From: Tim Townsend [<mailto:tim.townsend@westsussex.gov.uk>]
Sent: 07 November 2017 14:32
To: Planning.Responses
Cc: Michael Eastham; Gary Markwell
Subject: LU/121/17/RES - Approval of reserved matters for parcels C1 and part parcels B2, B4 and C2 - Land at former Toddington Nurseries, Littlehampton - WSCC highways comments dated 7th November 2017

**WEST SUSSEX COUNTY COUNCIL
STRATEGIC PLANNING CONSULTATION**

SUBJECT: LU/121/17/RES - Approval of reserved matters following outline consent LU/47/11/ for construction of 126 No. dwellings together with internal road network, car parking & landscaping.

LOCATION: Land North of, Toddington Lane, C1 & part Parcels B2, B4 & C2, Littlehampton, West Sussex, BN17 7PP.

Tree planting into Granite Setts on Main Avenue - Plan
Scale 1:50

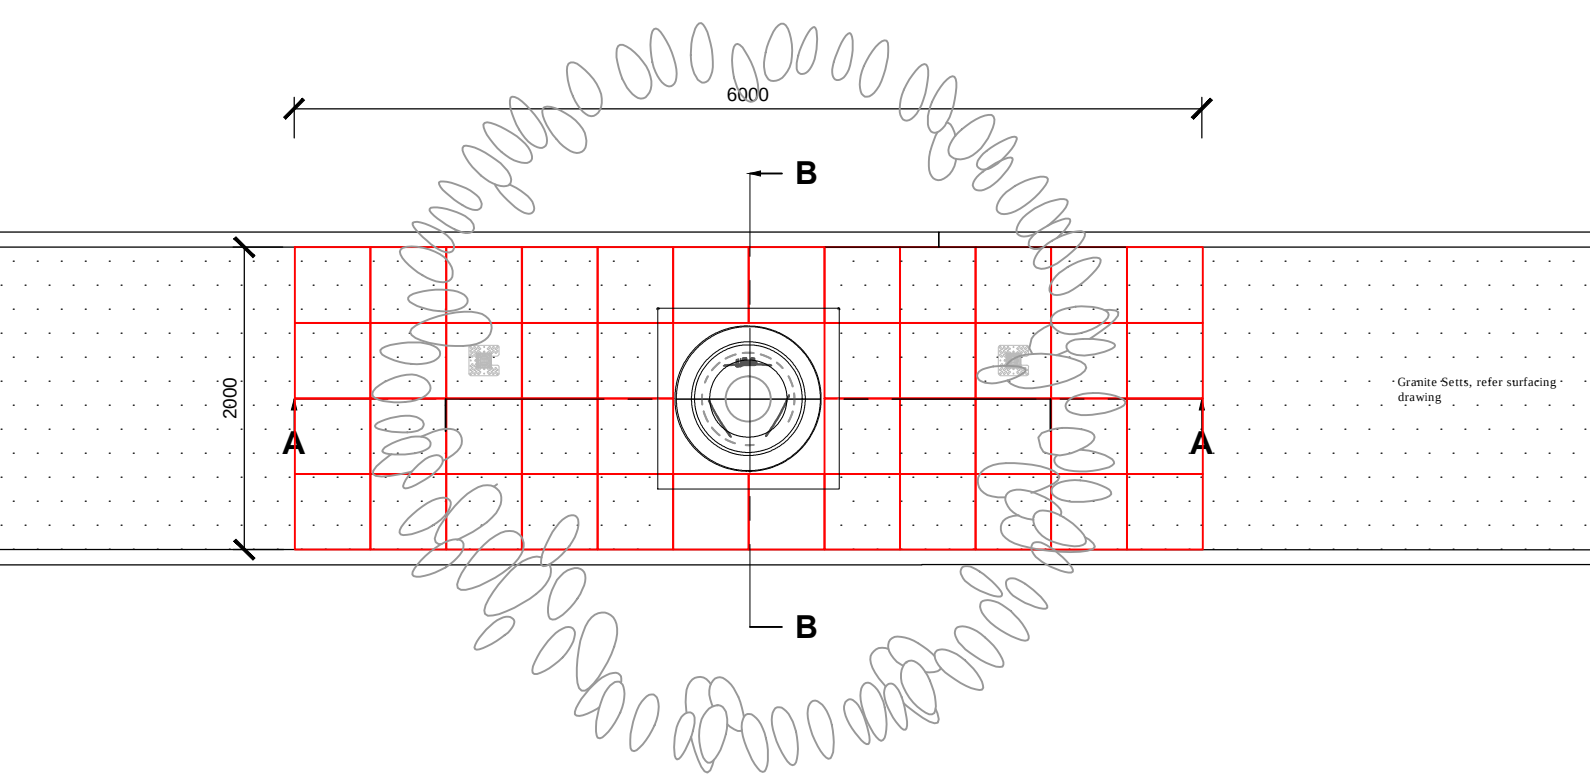
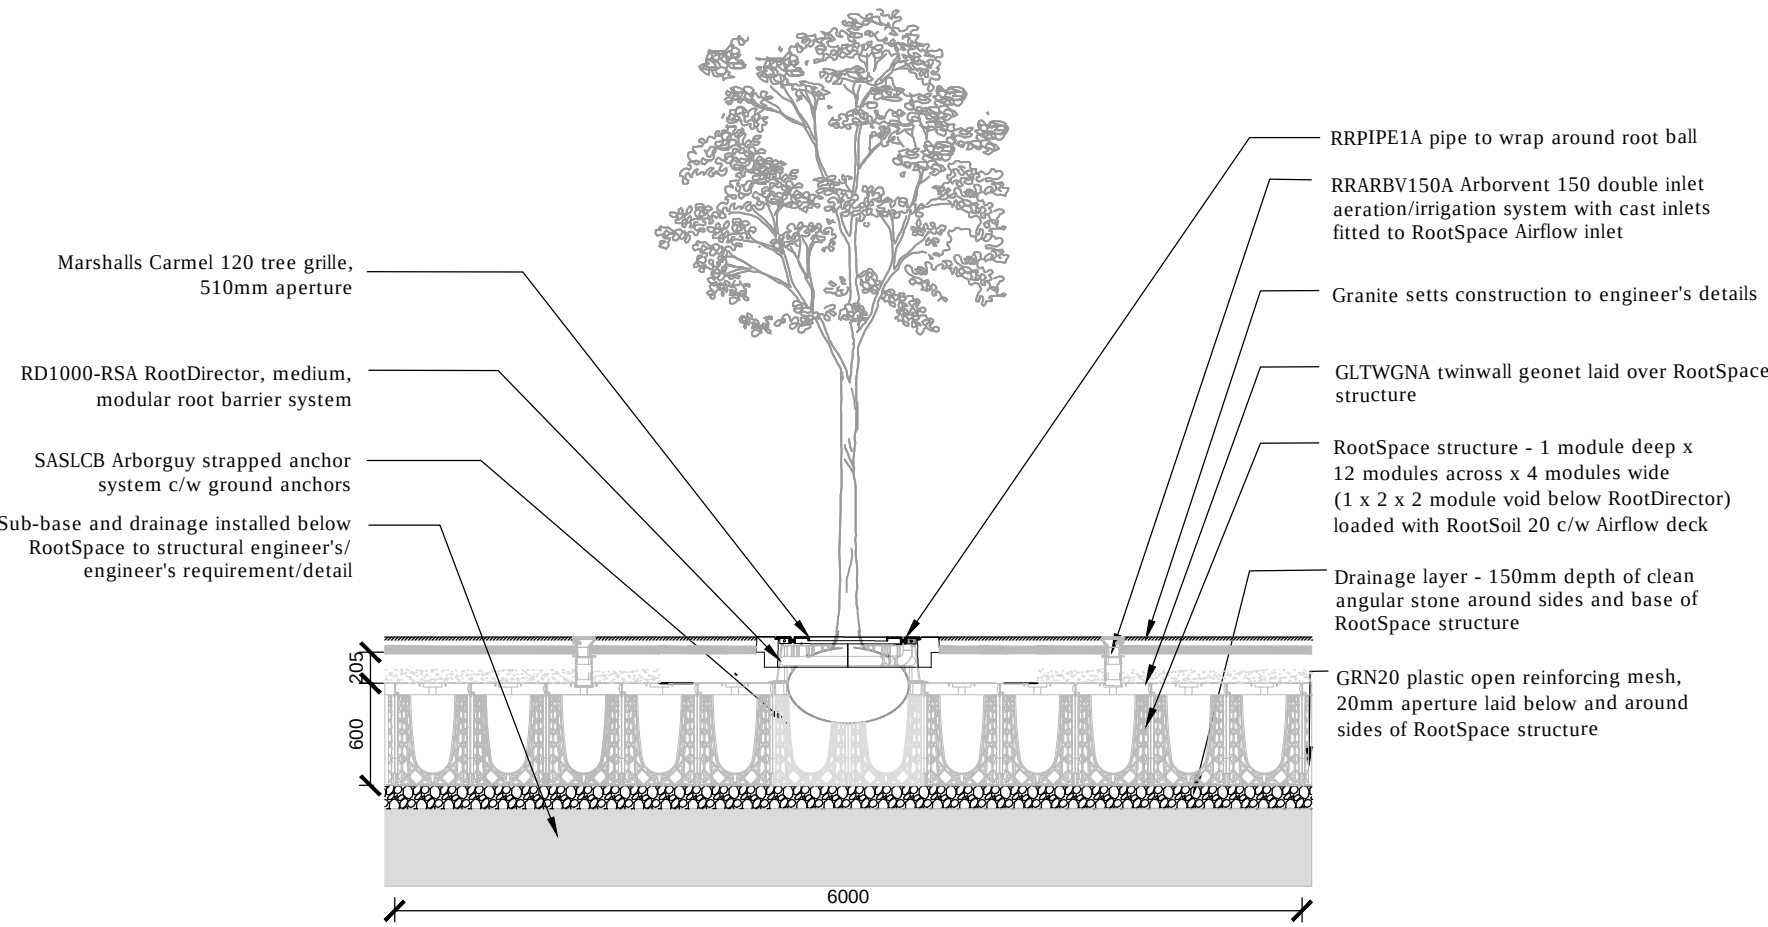
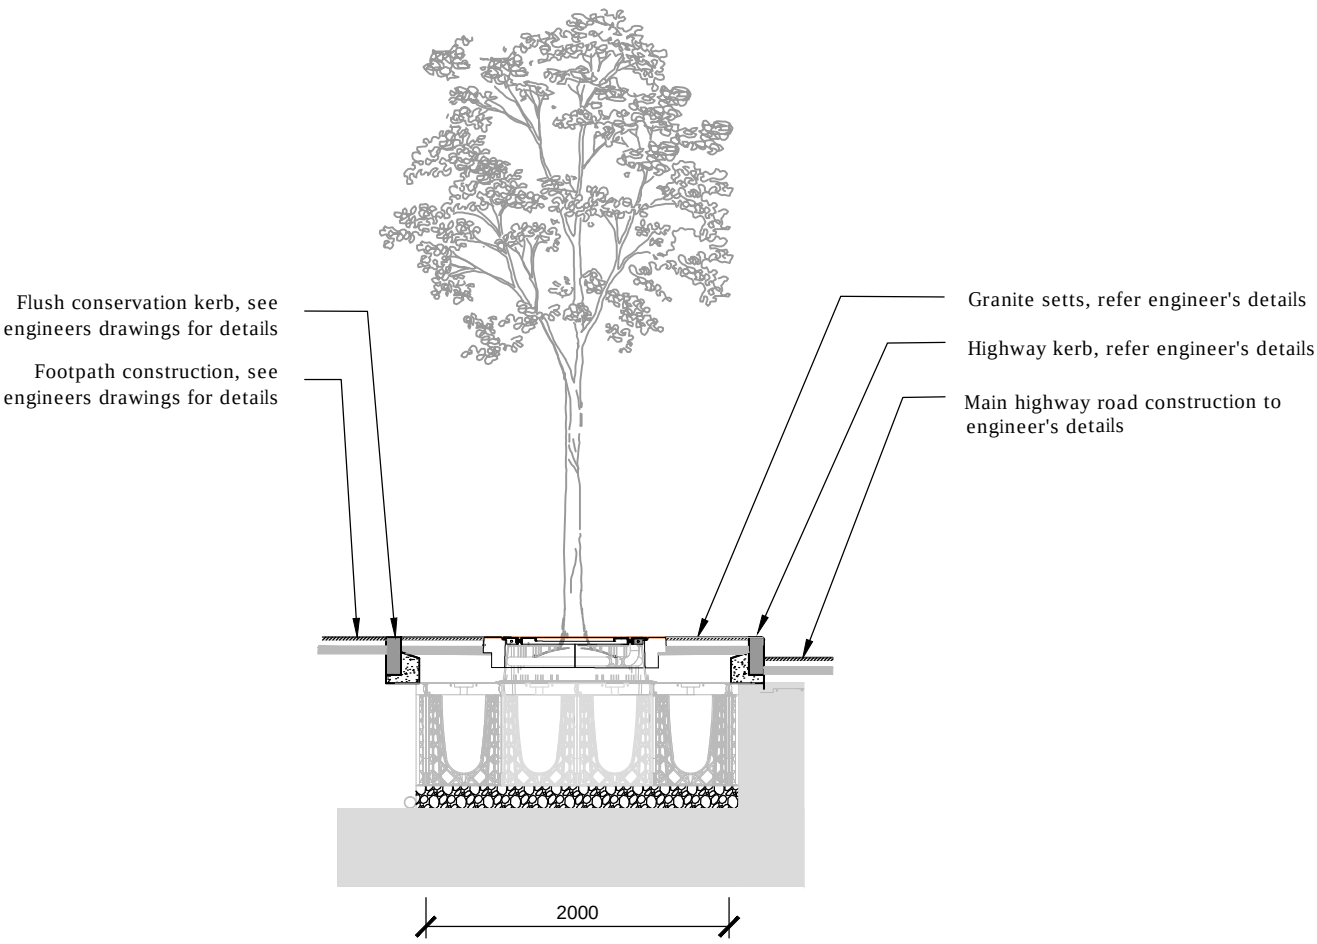
While the alignment of the initial section of spine road (intended for adoption) is generally acceptable, WSCC require that the specification for the hard landscaping in this area together with the details for the tree pits be provided and agreed prior to construction. Ideally, the rooting zone will be almost continuous underneath the surface. A condition to secure this should be attached to any consent.

With regard to hard landscaping (granite setts with trees pits adjacent are shown for parts of the main spine road leading into the development from the IDR), this type of treatment should be removed and replaced with grass. Granite setts are potentially a safety hazard if pedestrians choose to cross over them, a maintenance liability and can create issues with tree growth adjacent.

As this matter currently appears to be unresolved, the Highway Authority recommend that prior to any works commencing on-site that a specification be submitted and agreed between parties for the hard landscaping in this area together, including the details for the tree pits. Ideally, the rooting zone will be almost continuous underneath the surface.

The applicant's reply to this is that the comment relates to the continuous verge in front of the commercial / retail area. It would not be appropriate for this area to be turfed as pedestrian footfall will be such that the grass will not survive. In accordance with the outline Masterplan/S73 Development Framework Document a pedestrianised hard landscape area is what is envisaged for this area. They add that to overcome safety issues they have shown a railing to be placed around the tree pits to remove a trip hazard. However, a railing poses a maintenance burden so will need to be discussed further.
